From: jade lilley [REDACTED]
Sent: 20 January 2023 09:44
To: Planning
Subject: planning objection ref 23/00012/FUL

Objection to planning application 23/00012/FUL received Wed 4th Jan 2023.

Address of application 45 Blyth Road, Oldcotes, S81 8JA

Proposal –two bedroom detached dwelling

okn consulting services		35 newton gardens chapelthorn, sheffield, s35 2yw	
client Mrs Debra Proctor 43 Blyth Road, Oldcoates, Worksop, S81 8JA		project Proposed Dwelling	
contact Proposed Roof Plan, Section & Elevations			
job no.	014	rev.	A3
date	1:100	date	Dec 2022
© Architectural Knowledge 2022

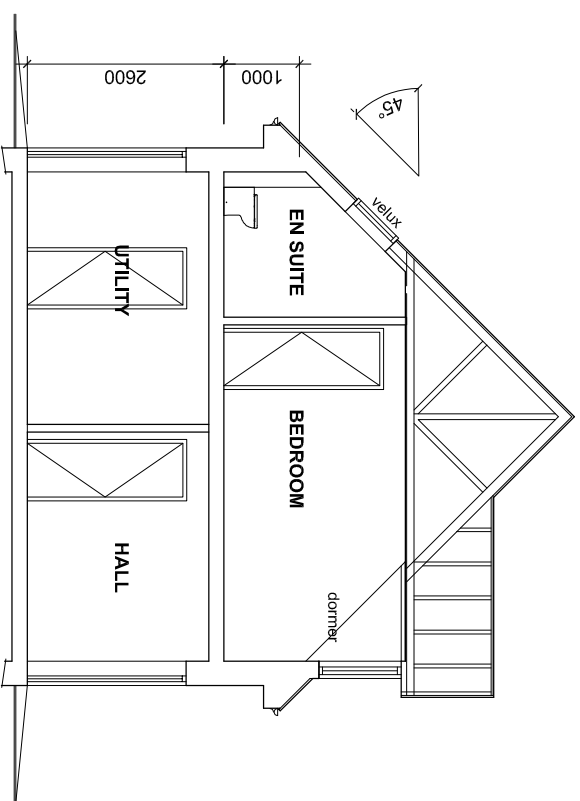
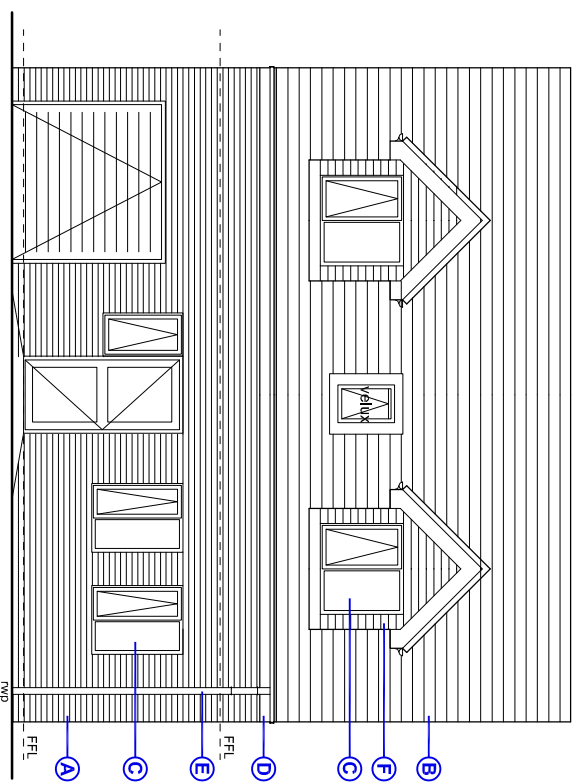
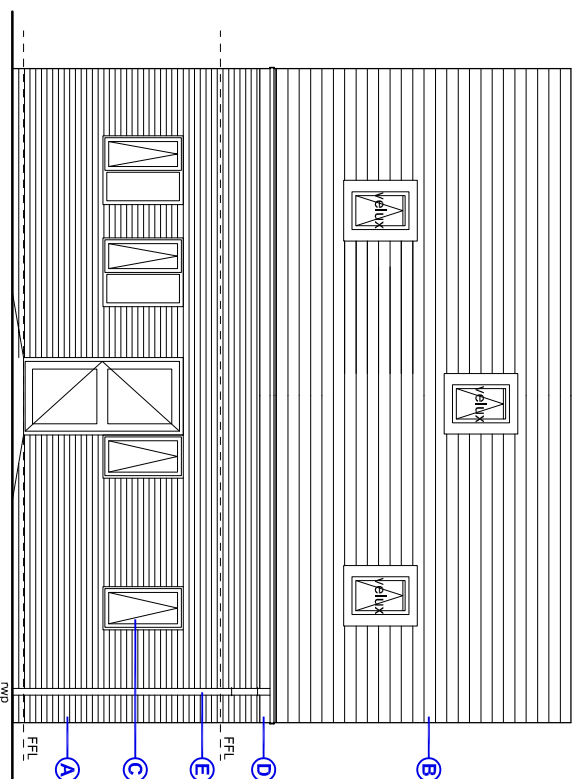
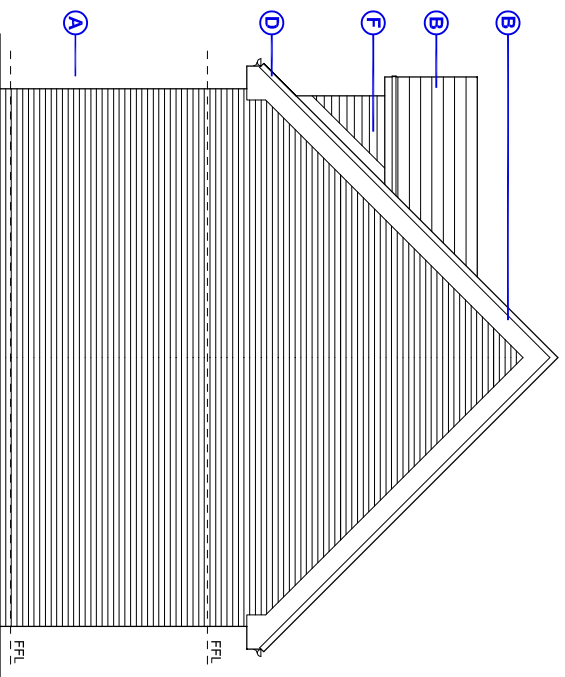
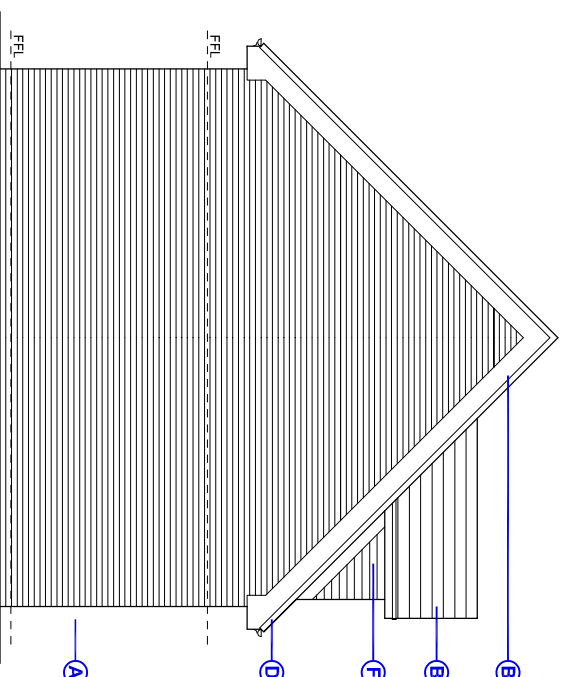
4. **Over shadowing** –as the proposed building is 2 story it will overshadow the neighbouring property and garden (number 43).
5. **Overbearing** –as the proposed building is 2 story it will be oppressive to neighbouring property being number 43.

| content: Proposed Site & Location Plan | |

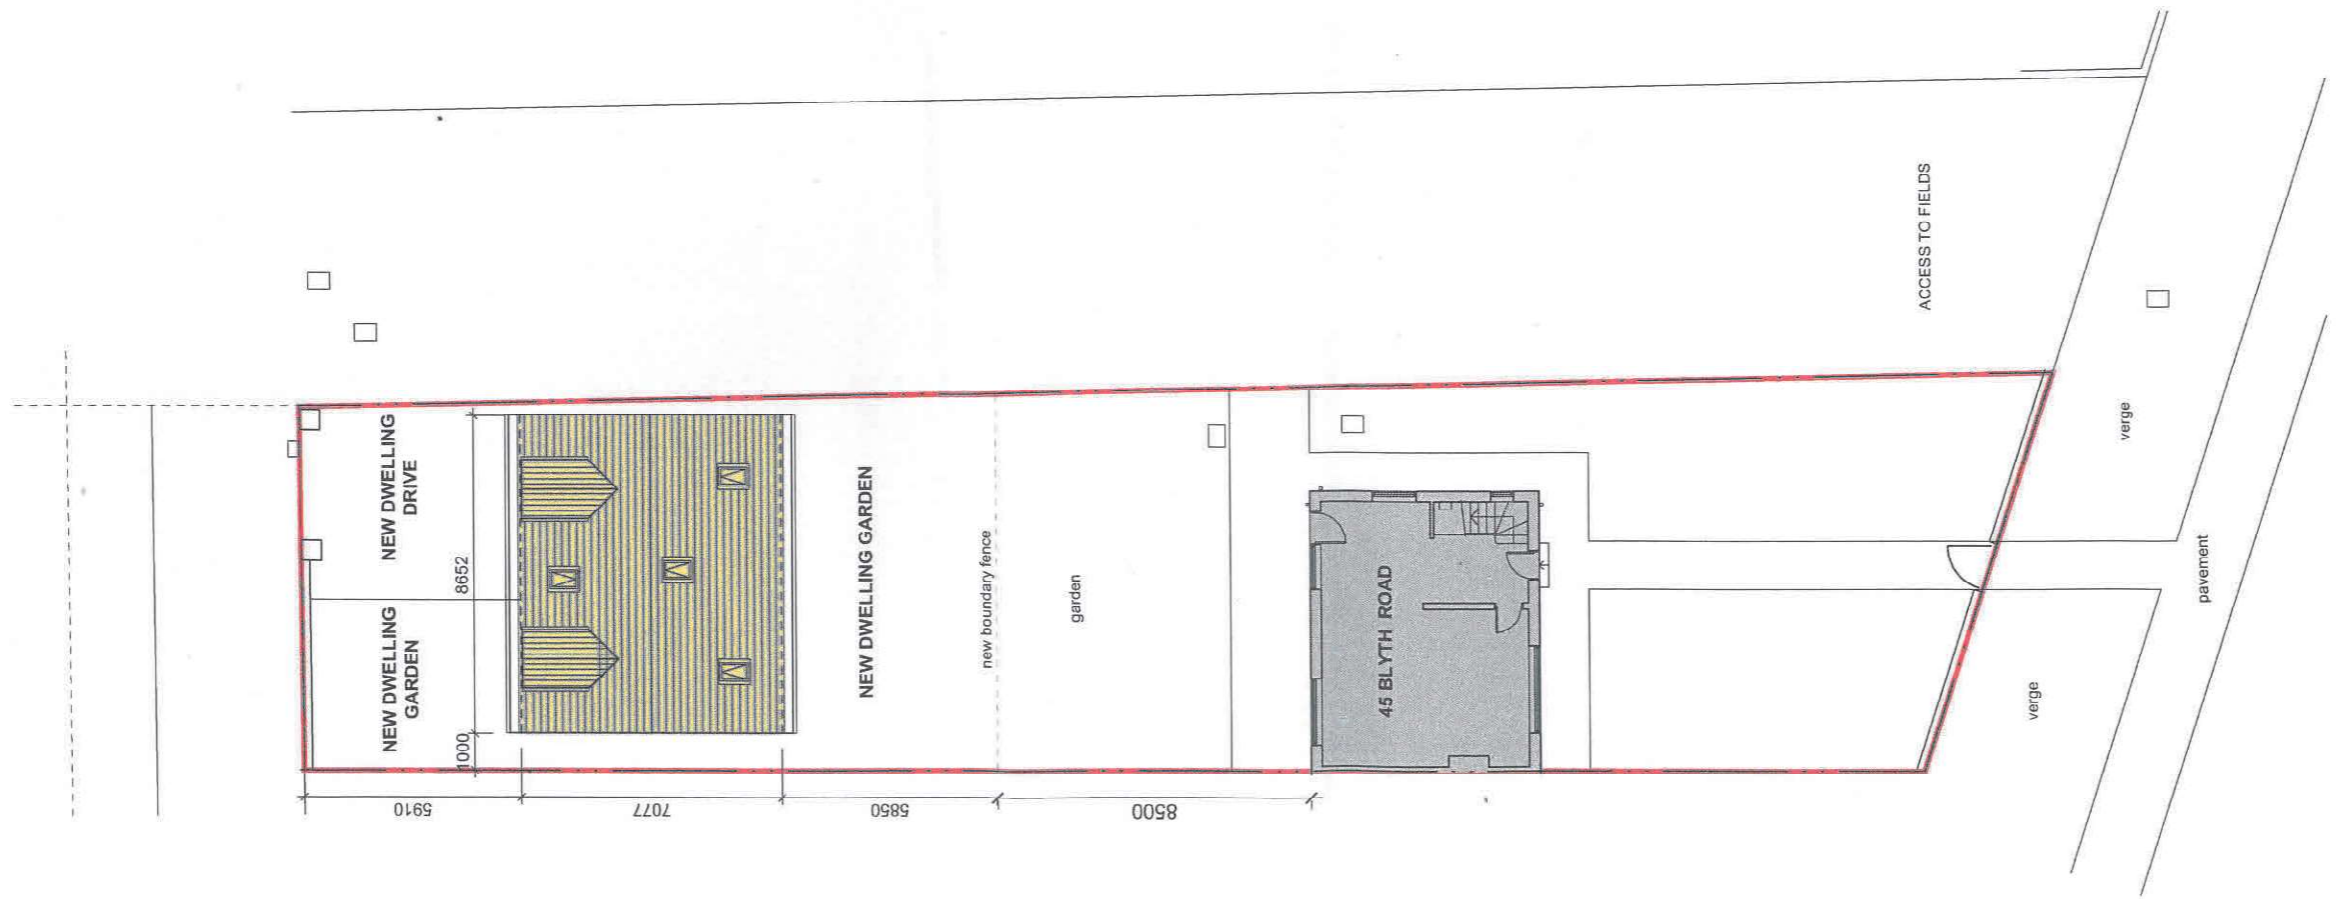
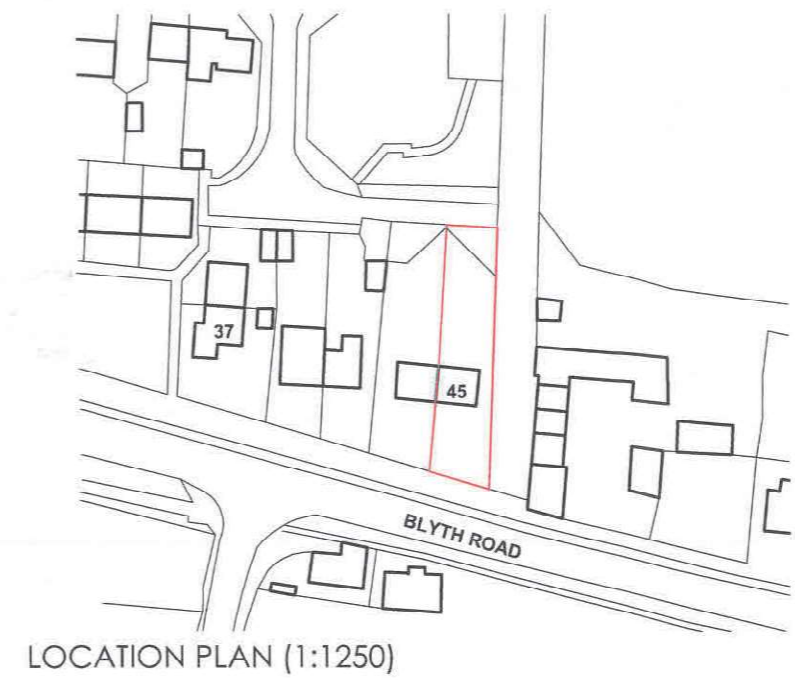
1. **No site notice** of planning application –other residents of the area not informed of intention to build.
2. **Loss of privacy/overlooking** - the property is proposed to be built 15 meters from the external wall of number 43/45 Blyth Road.

3. **Accessibility/parking**- the proposed build is at the end of a narrow grove and with a solid boundary built straight instead of at the slant it currently is (to allow manoeuvrability) it severely reduces manoeuvring space and as a consequence of this the level of parking space available on the street will also be diminished.
